From: Sue Howell
Sent: 05 March 2019 16:28
To: Michael Eastham
Cc: Planning.Responses; Joe Russell-Wells
Subject: FW: Planning Consultation on: AL/129/18/OUT

From: Sue Howell
Sent: 13 February 2019 12:38
To: Planning.Responses
Cc: Michael Eastham
Subject: RE: Planning Consultation on: AL/129/18/OUT

Comments from Greenspace

Description of Works: Outline application with some matters reserved for the development of 55 No. units with public open space & affordable housing (resubmission following AL/111/16/OUT).

Appendix II: proposed site

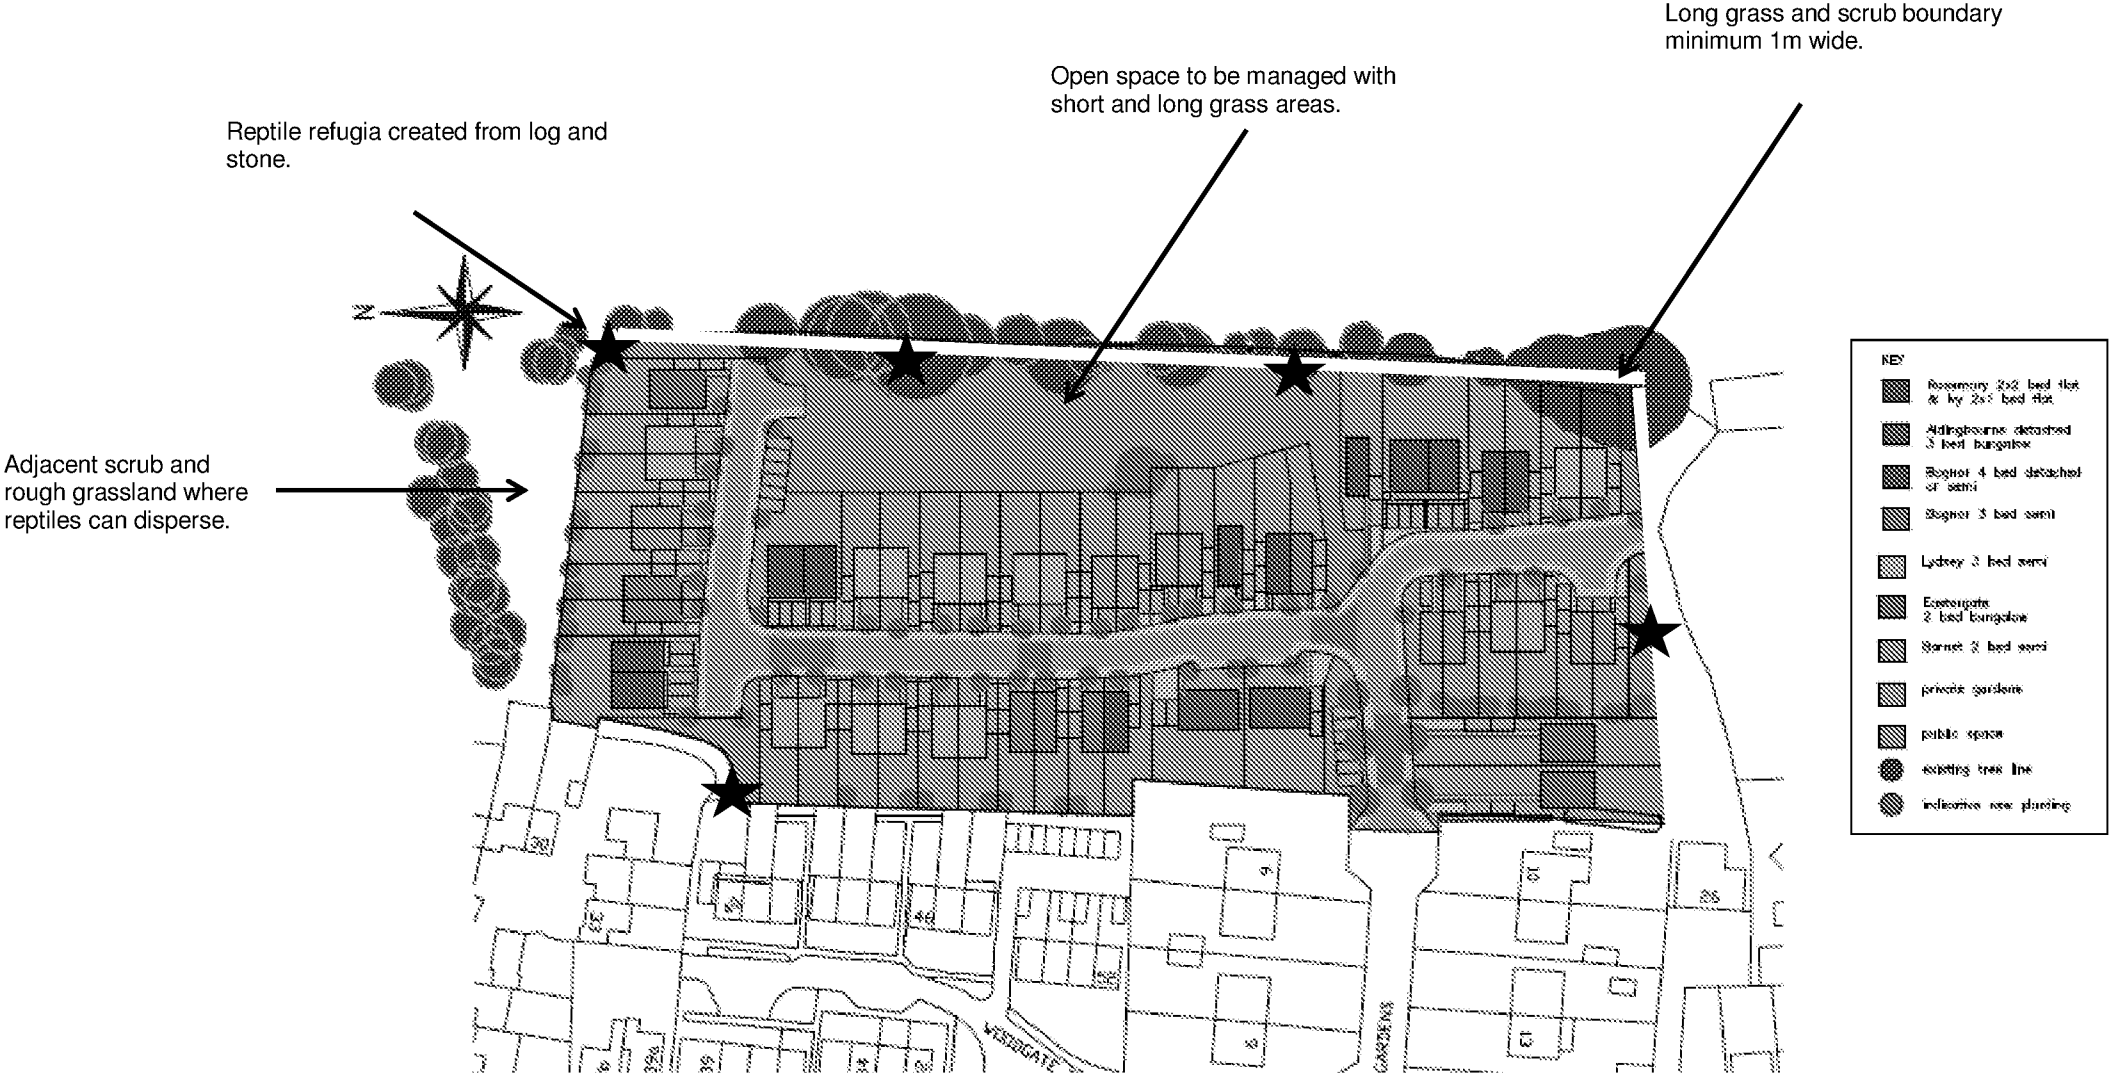
The open space indicated is still shown to the East of the development which whilst this would allow for the protection of the existing trees and TPO tree group it would provide a POS area

which is hidden away behind rear gardens where a centrally situated open space area would provide an area which would be better located. Consideration should be given to the layout proposed and whether the dwellings could be facing POS rather than as presently planned.

With the number of dwellings on this proposal being up to 55no this would trigger the need for onsite LEAP, LAP Multi Use Games area (MUGA) contribution and landscaped open space areas. There is no indication of where or how this is being provided on site and therefore we would request confirmation of this. S106 monies would be sought if provision for play if this is not met on site at a rate of £1600.00/dwelling (Oct 2000 index linked figure) to be allocated to local offsite play enhancement.
